Recommendation Report for Planning Permission for Works or Extension to a Dwelling

REF NO: A/96/22/HH

LOCATION: 20 Pine Trees Close
Angmering
BN16 4LT

PROPOSAL: Single storey rear extension with steps.

Client:		
Address of Works: 20 Pine Trees Close Angmering West Sussex BN16 4LT		
Drawing Title: Proposed Rear Extension Planning & Building Control		
Paper Size: A3	Date: Apr. 2022	
Job Number: AR - 171	Drawing Number: 04	Revision: Revision

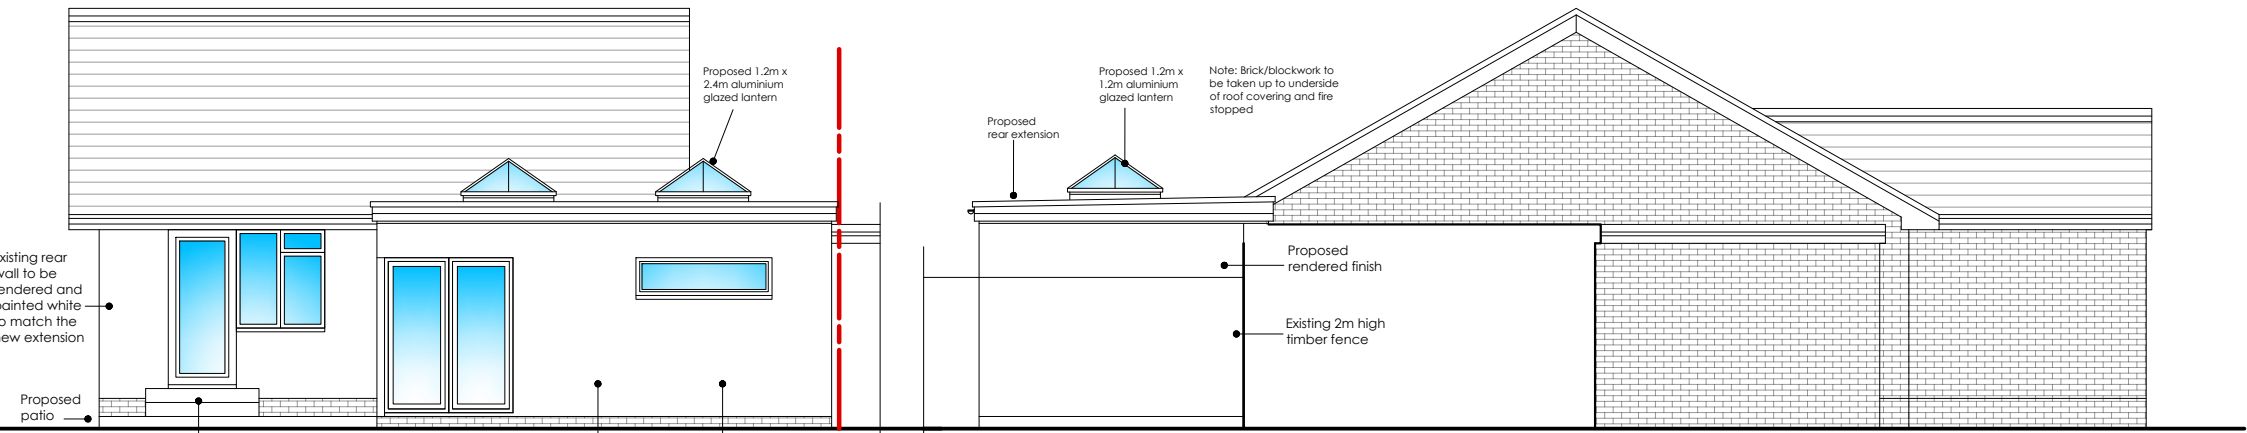
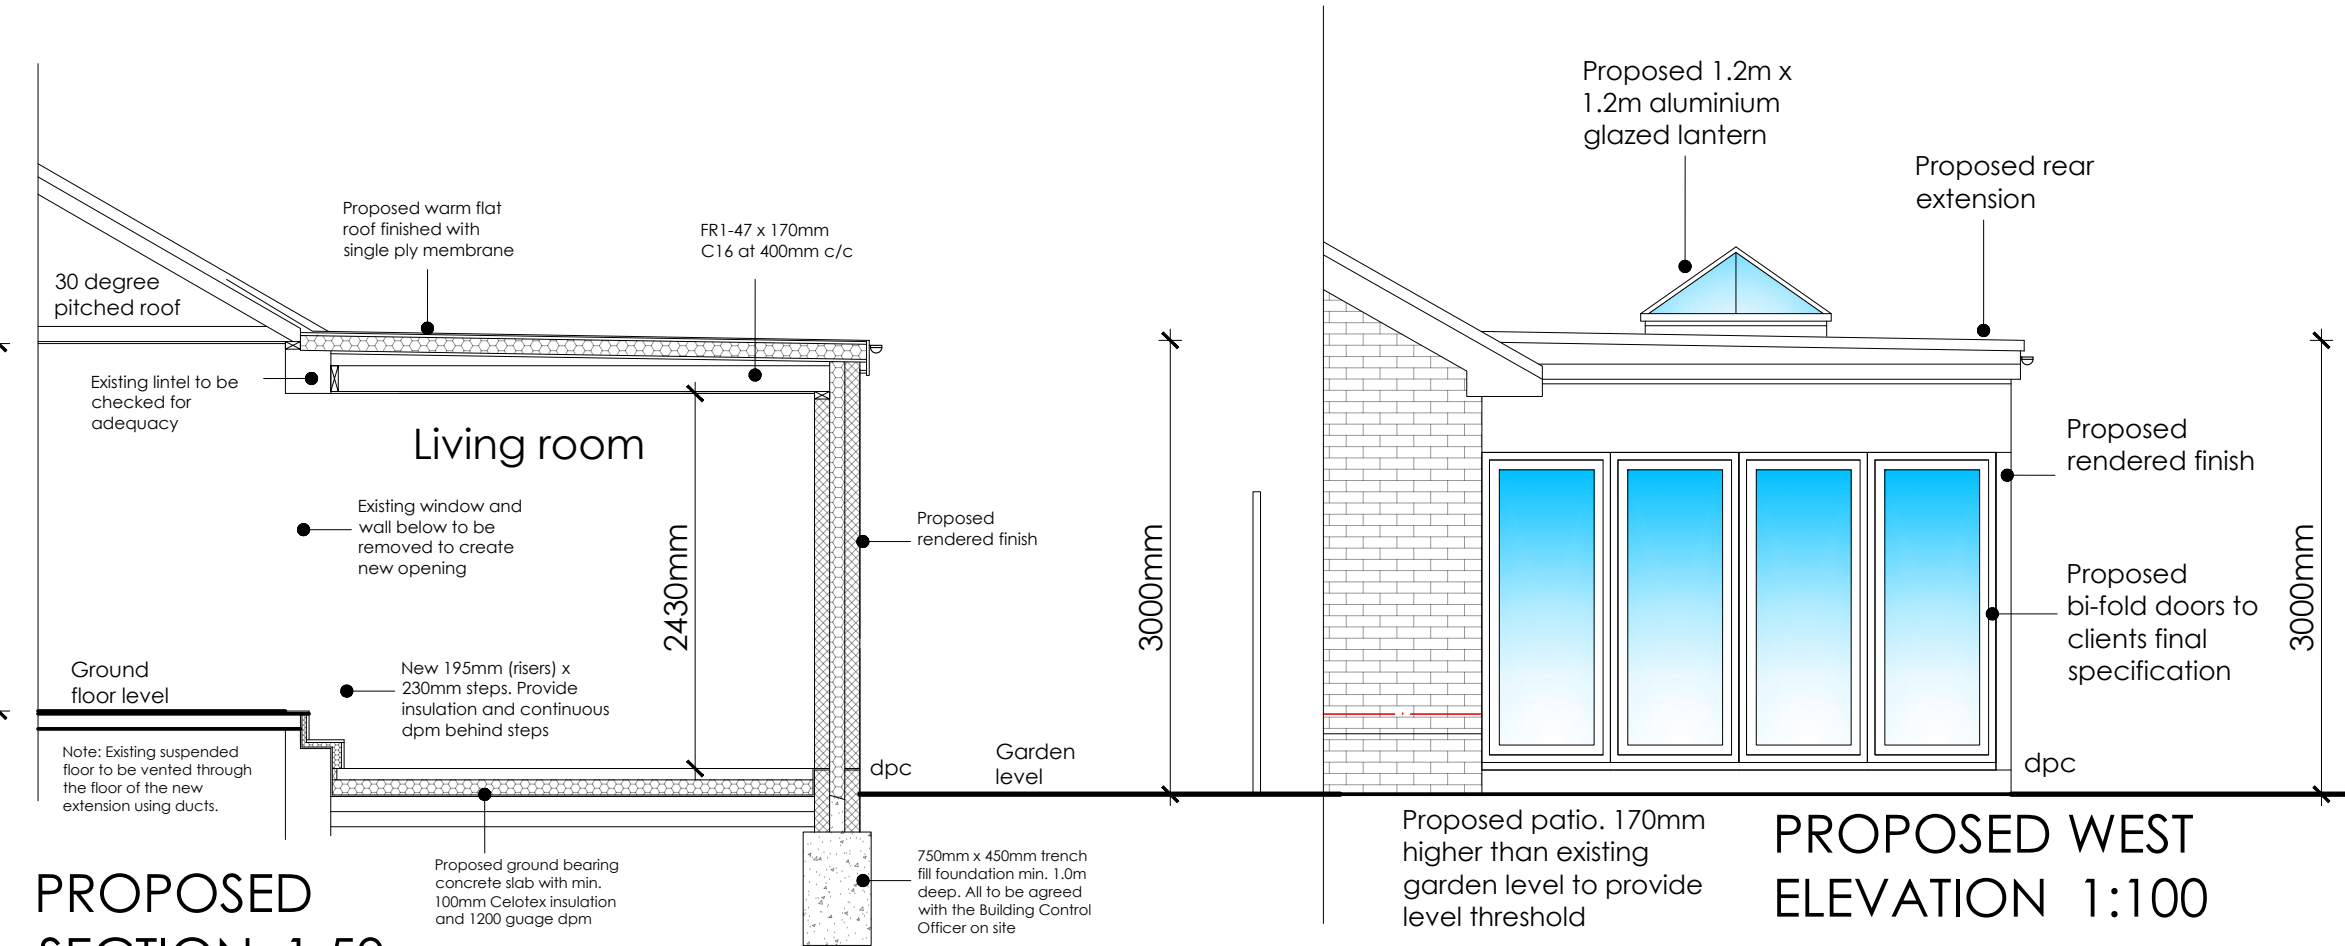
The proposed rear extension is of a subservient scale. This extension is to be approx. 6m in width, 3.5m in depth, 3.6m at peak height with eaves at 2.9m. The roof design is a flat top shallow pitch with 2 No. rooflights of an acceptable design. This proposed extension is similar in scale to others within the locality and is not out of character.

The extension and rear elevation are to be rendered in white which contrasts with the existing facing brickwork. There are examples of white render being used within the locality. Being sited to the rear elevation, the contrasting materials of the proposal with the host dwelling will not have any adverse visual impact on the wider street scene. Additionally, in rendering the rear elevation and the proposed extension, the extension is better visually integrated with rear elevation.

There is to be a set of new stairs from the existing rear door, these are of a minor scale and are acceptable in design.

PROPOSED GROUND FLOOR PLAN 1:50

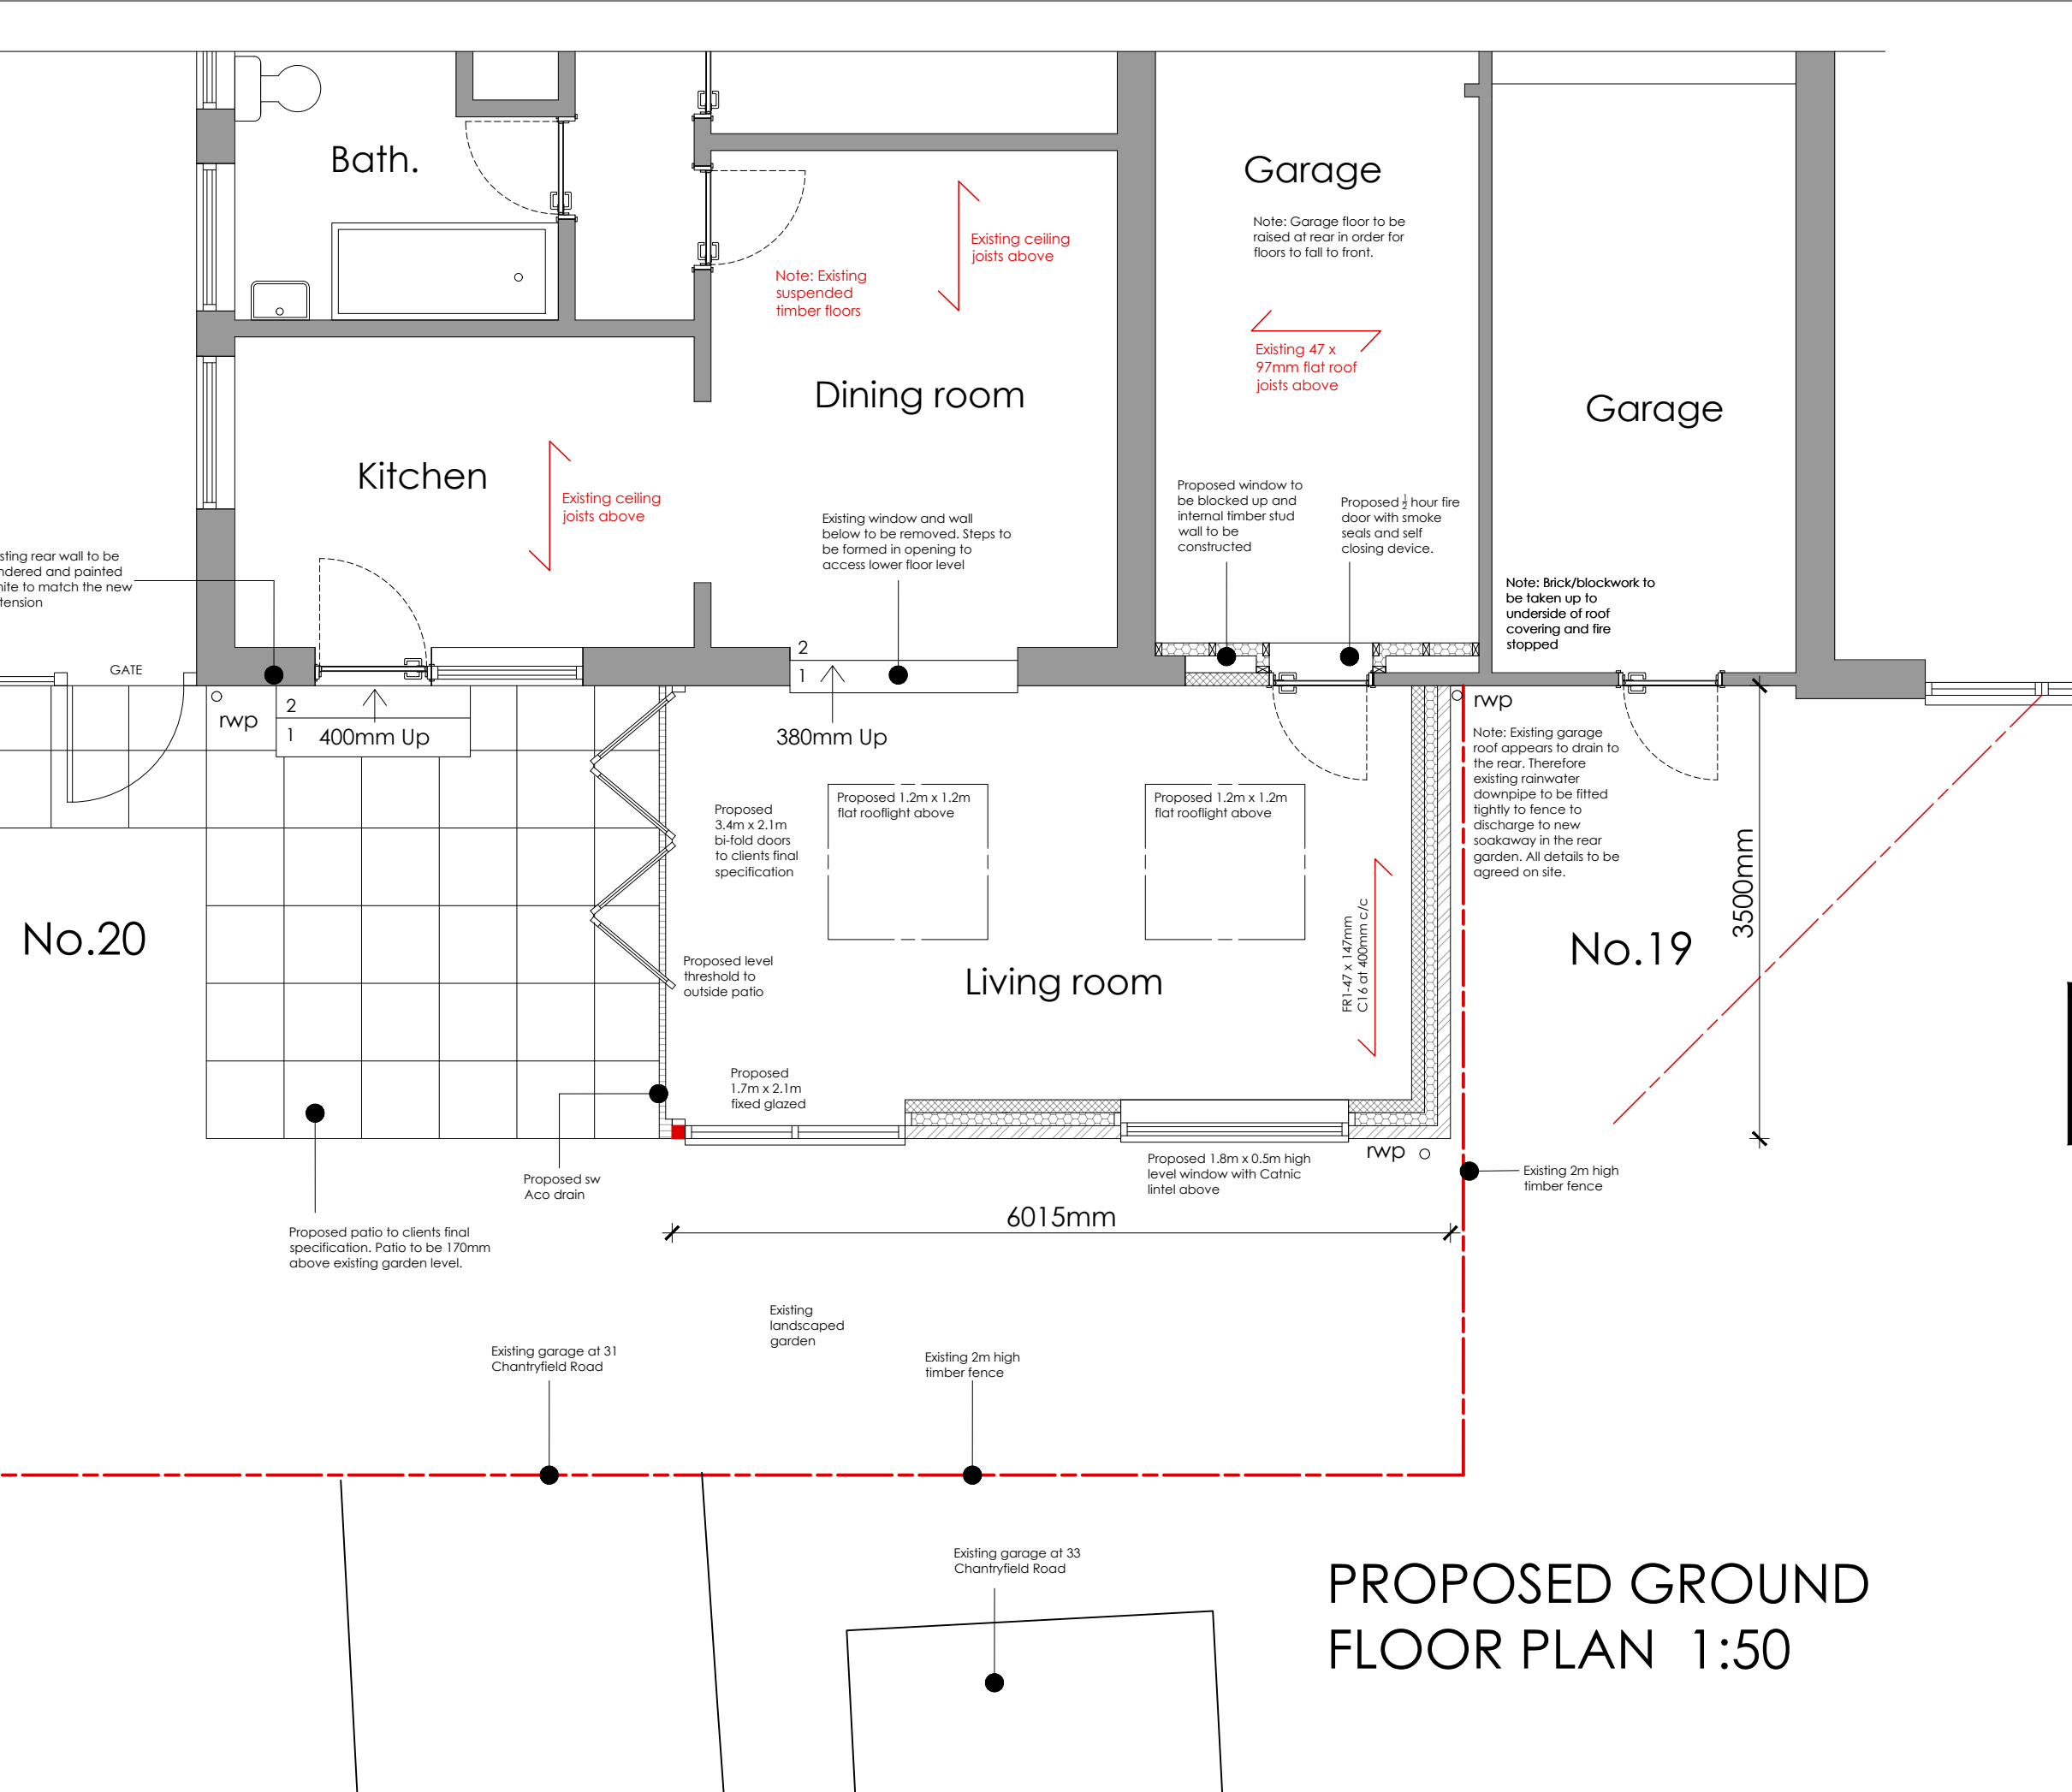
There is to be various new ground floor viewpoints consisting of windows and glass doors. These are at

ground floor level and look out to the rear amenity space which features a boundary fence around the perimeter. There will be no adverse impacts by way of overlooking on any neighbouring properties.
